**Please ask for:** Tegan Chenery  
**Your reference:** PPA492705663  
**Our reference:** DC/23/01056  
**E-mail:** [heritage@baberghmidsuffolk.gov.uk](mailto:heritage@baberghmidsuffolk.gov.uk)  
**Date:** 11th April 2023

**Proposal:** Heritage pre app meeting on site with written response - Internal re-ordering. Additional rear and side windows and dormer windows. Rebuild rear lean-to. Demolition of uPVC conservatory. New single storey flat roof extension. Replacement of cementitious external render and interior plaster.

**Location:** 3 Polstead Street, Stoke By Nayland, Colchester, Suffolk CO6 4SA

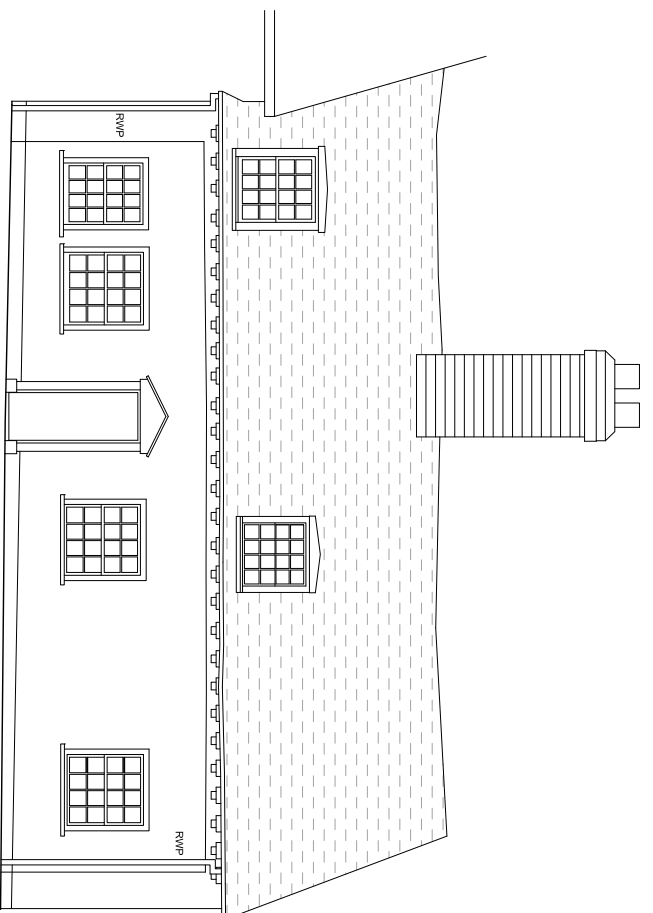
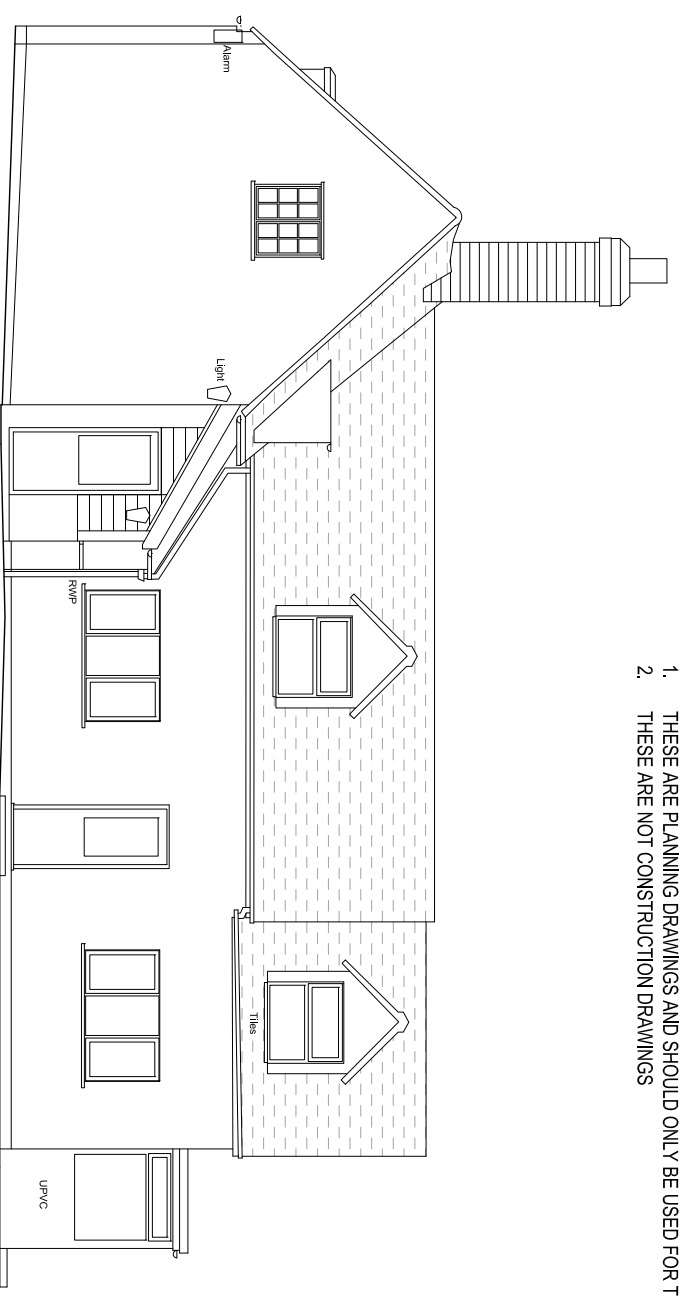
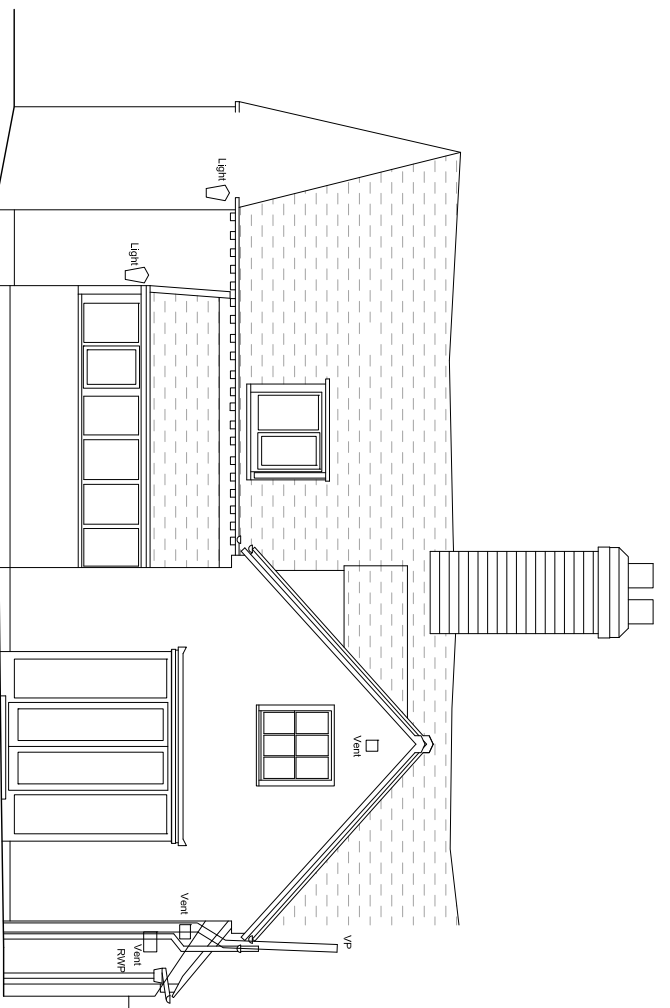
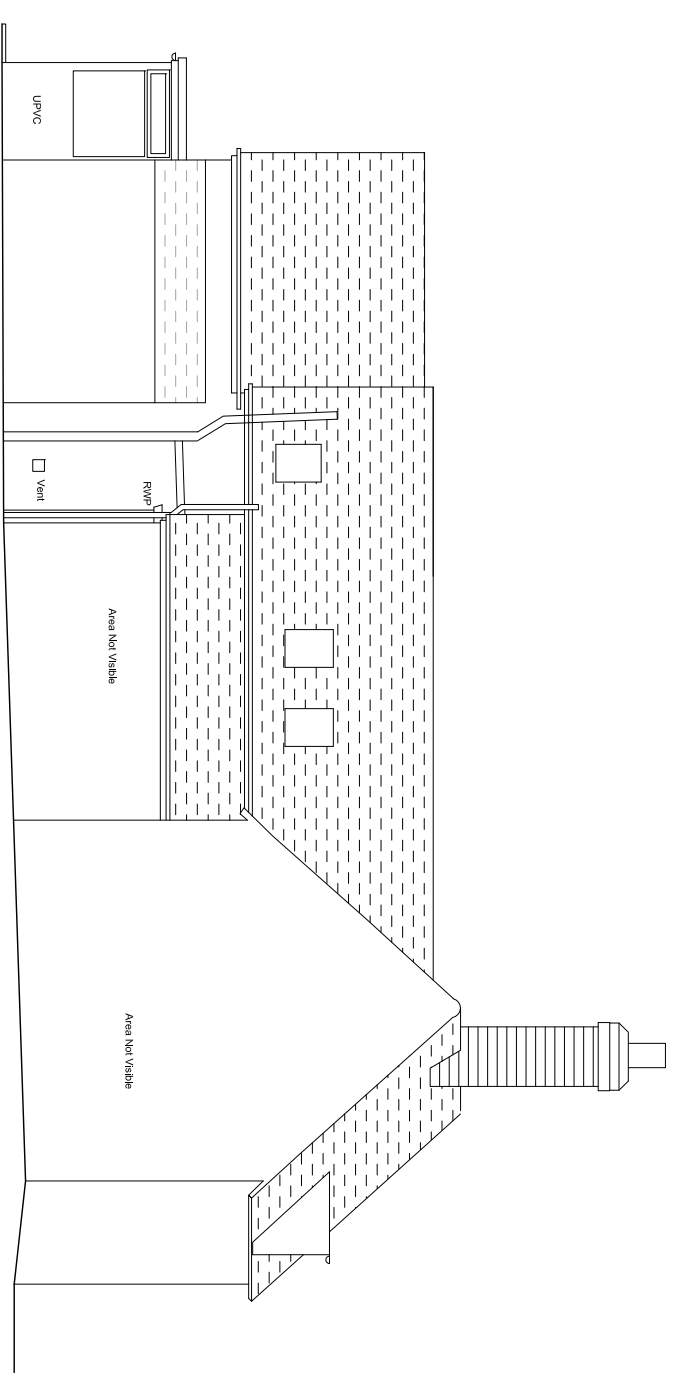
As discussed, there should be an appropriate hierarchy maintained between the historic principal range and the rear additions. In the current proposal, the glazing on the rear additions appears to disrupt that hierarchy, due to its size, so the rear additions would not appear subservient to the historic front. As such, I recommend reducing the size of the glazing to the rear, pitched roof additions, particularly the windows to the north elevation and those in the gable to the east, which should be a two-light window. The additional dormer proposed to the rear should also be omitted. Three dormers would increase the visual prominence and massing of the rear range, and so I recommend a single, conservation rooflight might be a suitable alternative.

However, I have some concerns about the overall number of rooflights which would be present on the building, as already proposed, and their cumulative impact. One rooflight should be removed from the lean-to to the north elevation, and both rooflights removed from the lean-to entrance to the east elevation. This would help to simplify the designs and limit the visual intrusion in the roof slopes. The entrance lean-to would already incorporate a large amount of glazing in elevation, with slender metal frames, allowing ample daylight into this area, so I do not consider these rooflights fundamental to the scheme.

The principle of a contemporary flat roofed extension to the existing modern rear range is not opposed. However, the scale should be reduced. Currently, there is little articulation between the walls and roof of the extension, to the walls of the rear range. The extension should be stepped in more notably, as well as the overall footprint and the finished height reduced, again to help articulate the subservience of this element and to avoid creating an imbalance between the modern additions to the proportions of the historic core. The north elevation of the contemporary extension should also have some form of articulation to help reduce its massing and potentially monolithic form, which is currently shown as a plain, rendered wall. This could either be through vertical timber cladding, or some other form sensitive detailing.
